14-H-15
43-45 Turner Street
Hagge Residence
Cyns Hagge

**CITY OF PORTLAND, MAINE
DEVELOPMENT REVIEW APPLICATION
PLANNING DEPARTMENT PROCESSING FORM
Planning Copy**

Hagge Residence
Project Name/Description

Subject: Application ID: 2007-0212

HAGGE RESIDENCE 45 TURNER ST.
 SOUTH ELEVATION PROPOSAL
 1/4" = 1'-0" 3 | 26 | 08

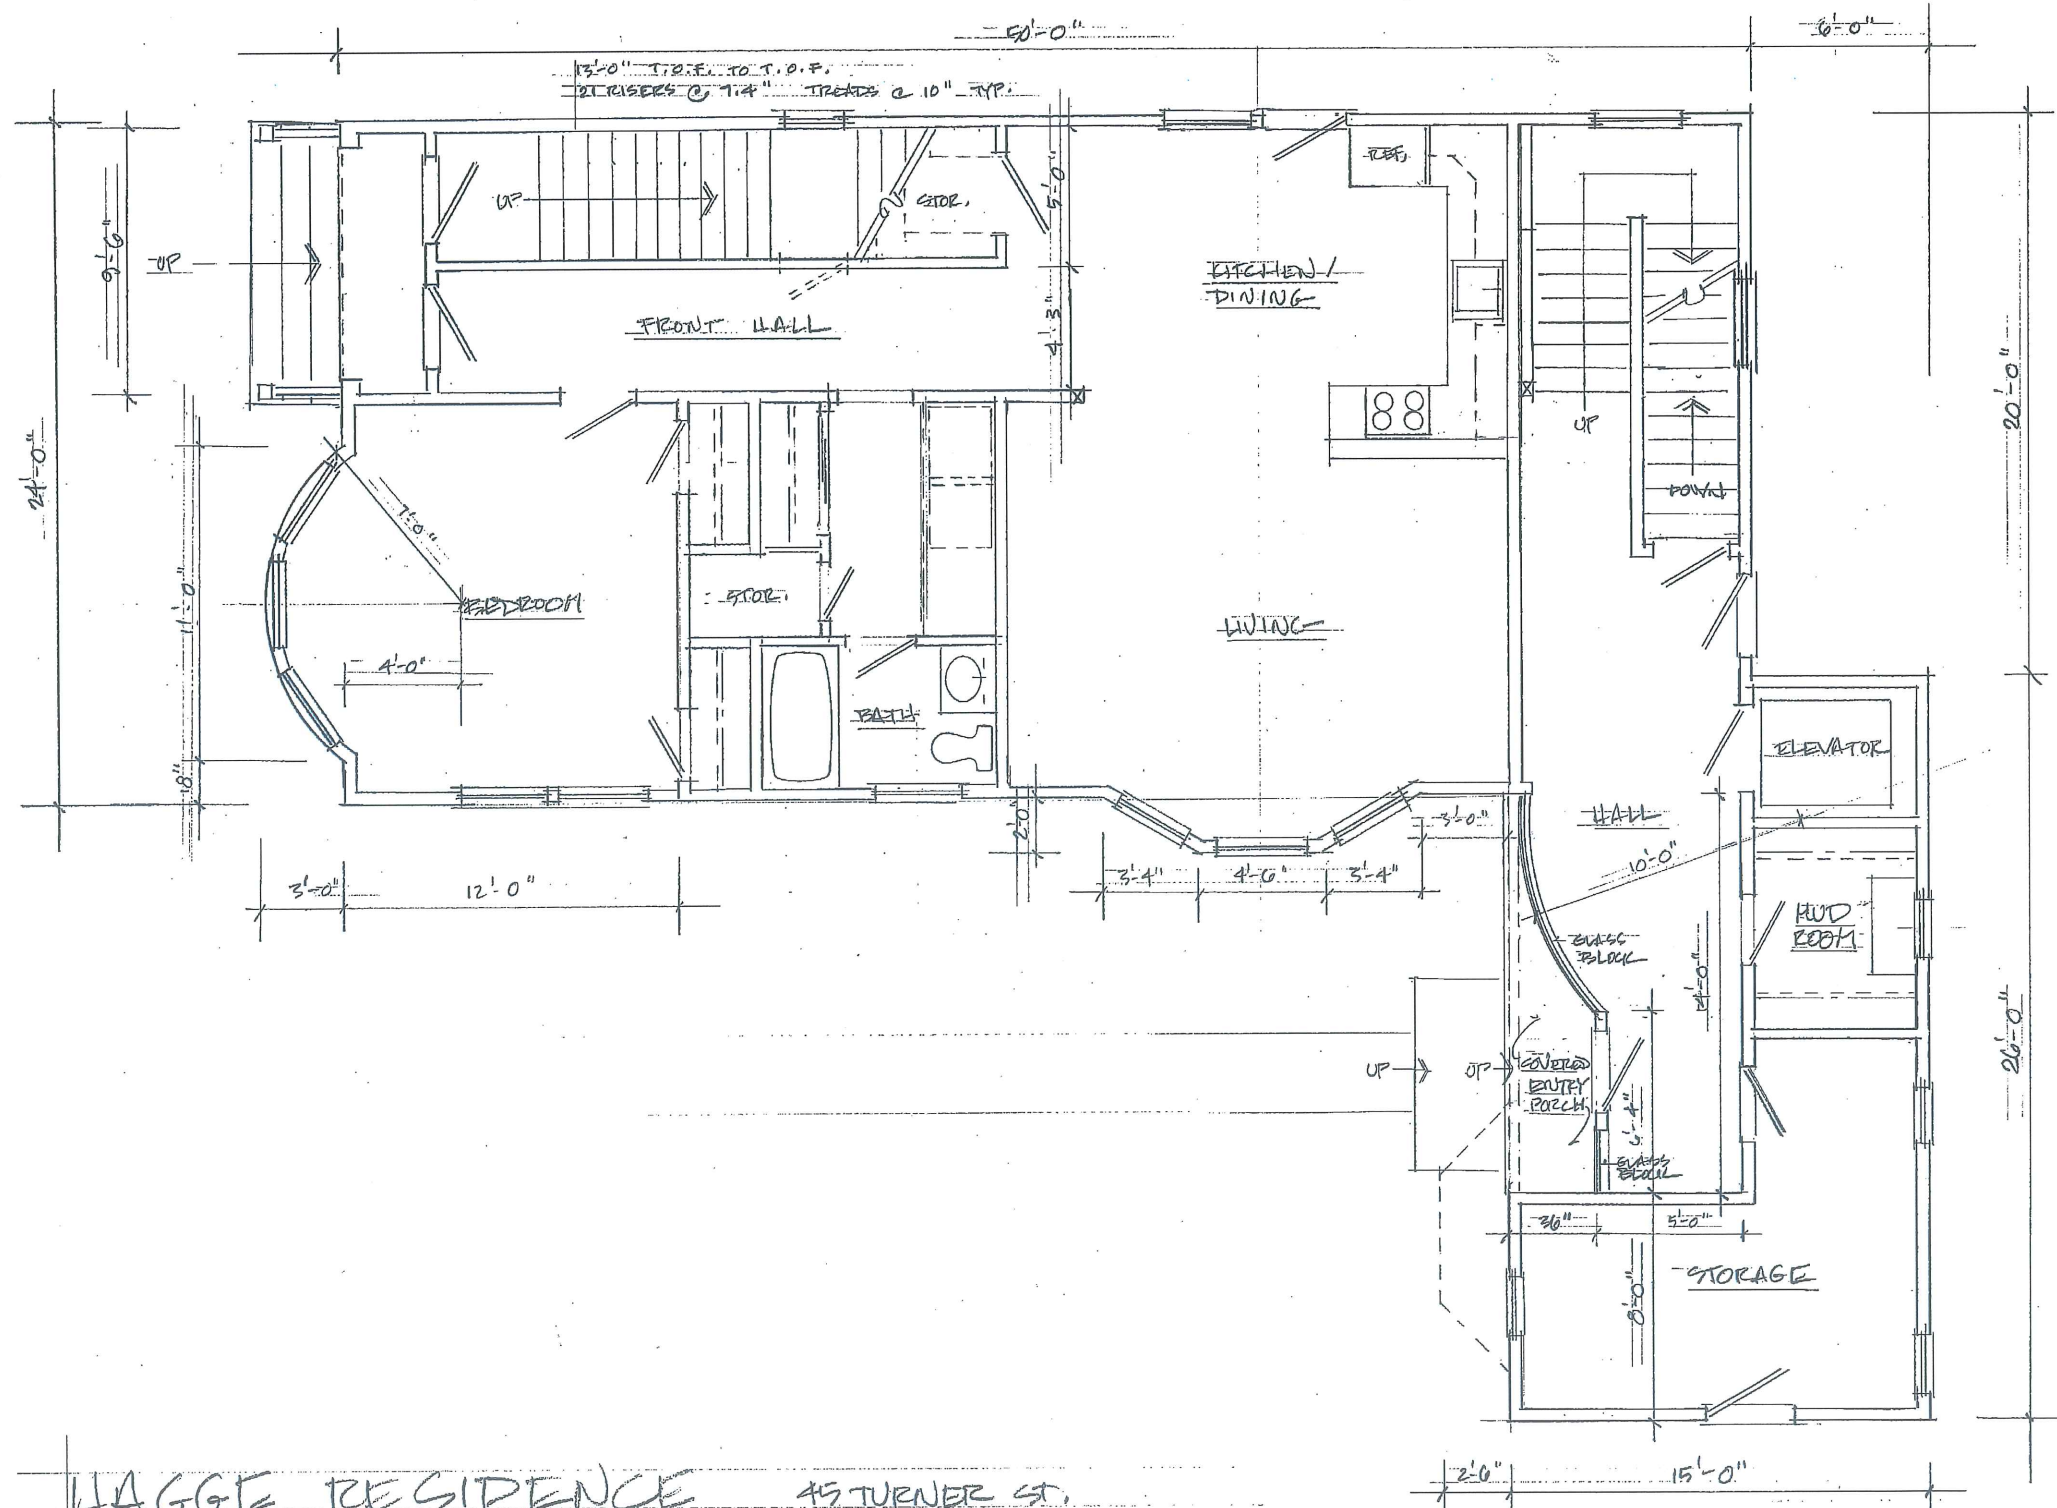
Barbara, The developer of the Turner St. duplex (Cyrus Hagge) has made some revisions to the facade of the building. Phil has taken some pictures of the completed facade and Cyrus has submitted some facade plans of the changes. Apparently he is nearing a c of o request.

The most significant change is a curvilinear glass block field adjacent to the secondary entrance to the building. The primary part of the building is built to the street line (with an entrance) but a secondary wing of the building is set back about 45 from the street.

I've looked at the r-6 infill standards and I believe this project meets the standards. There are two standards that reference not using more than 2 different types of windows. One of the standards (F-2) states no more than two window types "except where there is a design justification." Initially I thought glass block should be considered a window but glass block is glass not a window.
